**WELWYN HATFIELD BOROUGH COUNCIL
EXECUTIVE DIRECTOR - PLANNING, PUBLIC PROTECTION AND GOVERNANCE**

Application No: 6/2021/1132/LAWP
Location: 5 Bell Lane Brookmans Park Hatfield AL9 7AY
Proposal: Certificate of lawfulness for the erection of a single storey detached garage, single storey rear conservatory, and swimming pool with enclosure
Officer: Ms Lois-May Chapman

Recommendation: Refused

Title:
 Proposed extension & outbuildings
 5 Bell Lane, Brookmans Park
 Hertfordshire AL9 7AY
 Proposed pool house elevations

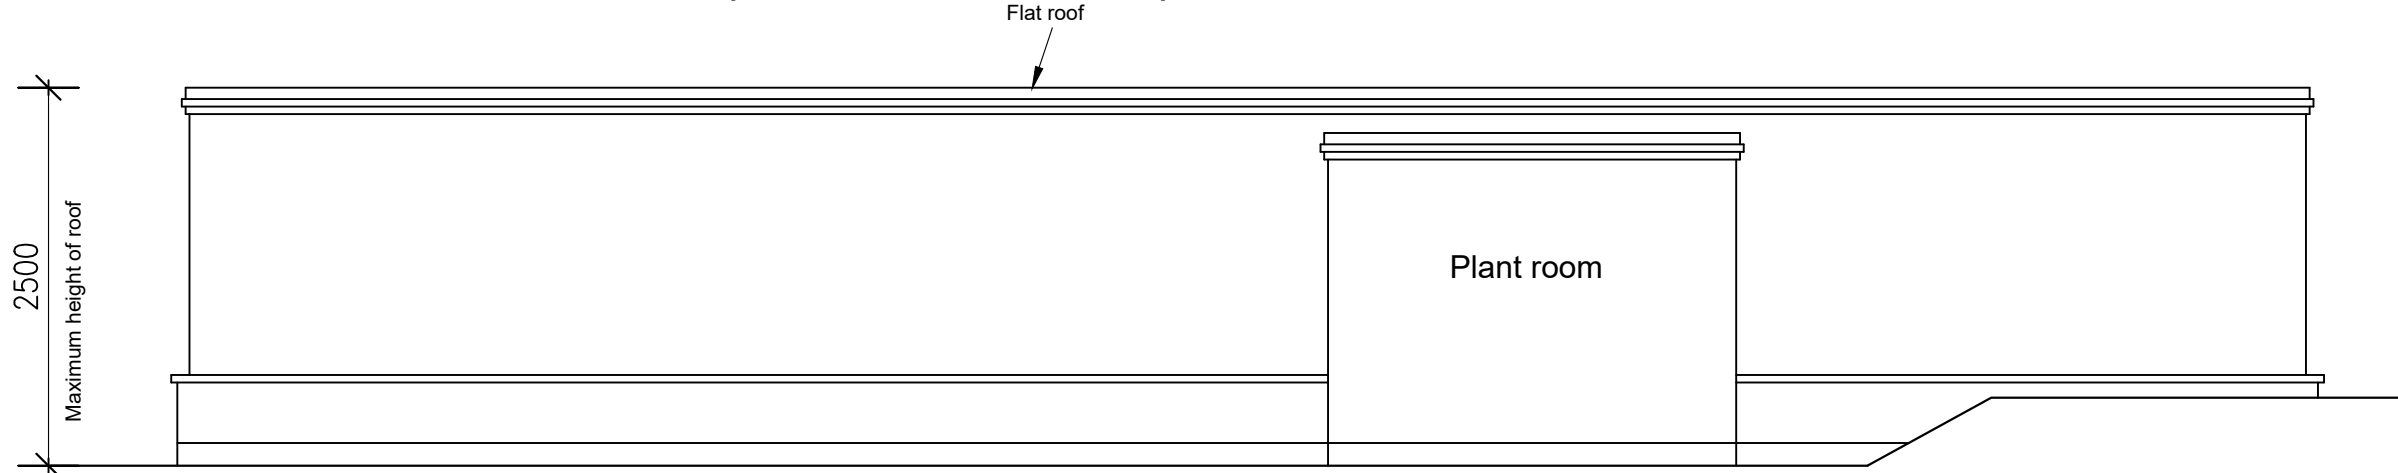
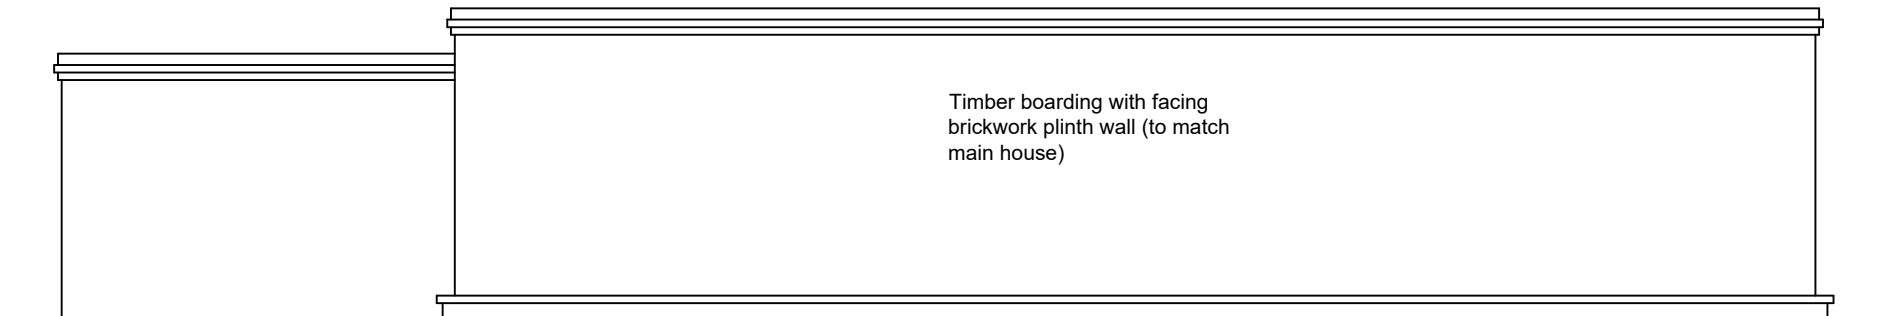
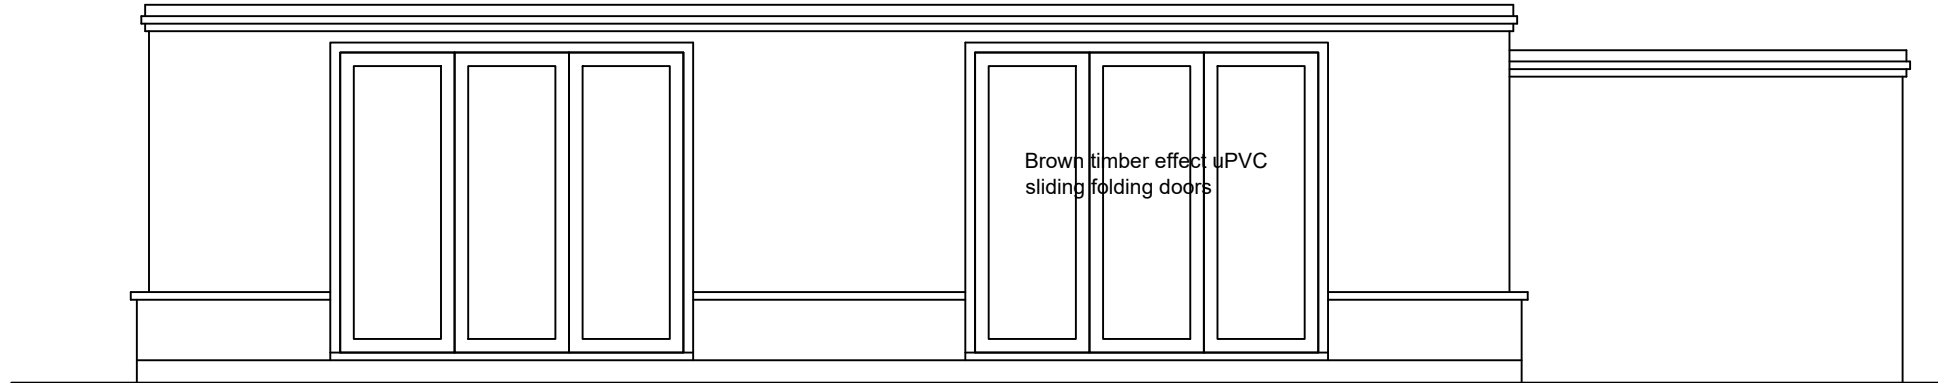
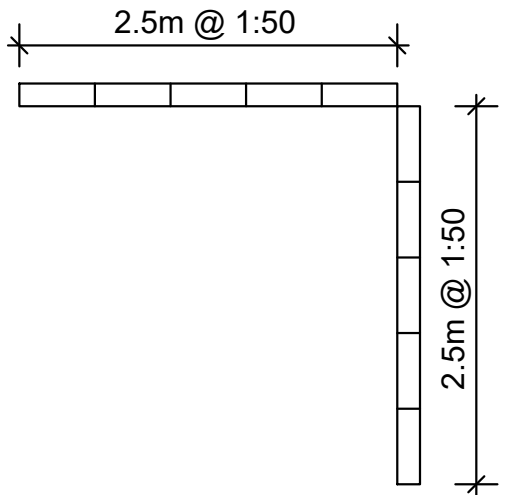
(i) it relates to a dwelling or a microwave antenna; or	N	N
(j) the capacity of the container would exceed 3,500 litres.	N	N
E.2 deliberately excluded		
E.3 In the case of any land within the curtilage of the dwellinghouse which is article 2(3) land, development is not permitted by Class E if any part of the building, enclosure, pool or container would be situated on land between a wall forming a side elevation of the dwellinghouse and the boundary of the curtilage of the dwellinghouse.	N/A	N
Discussion		
<p>The proposed gap between the triple garage and the side elevation of the house does not constitute as a functional gap. From the plans submitted it would appear that the garage is linked to the dwellinghouse.</p> <p>Following this little information has been provided to sustain this application for example no elevational drawings of the proposed retaining wall have been provided and the drawings for the swimming pool refer to the building having two front elevations.</p>

Conclusion		
The development would not accord with Schedule 2, Part 1, Class E of the Town and Country Planning (General Permitted Development)(England) Order 2015, as amended.
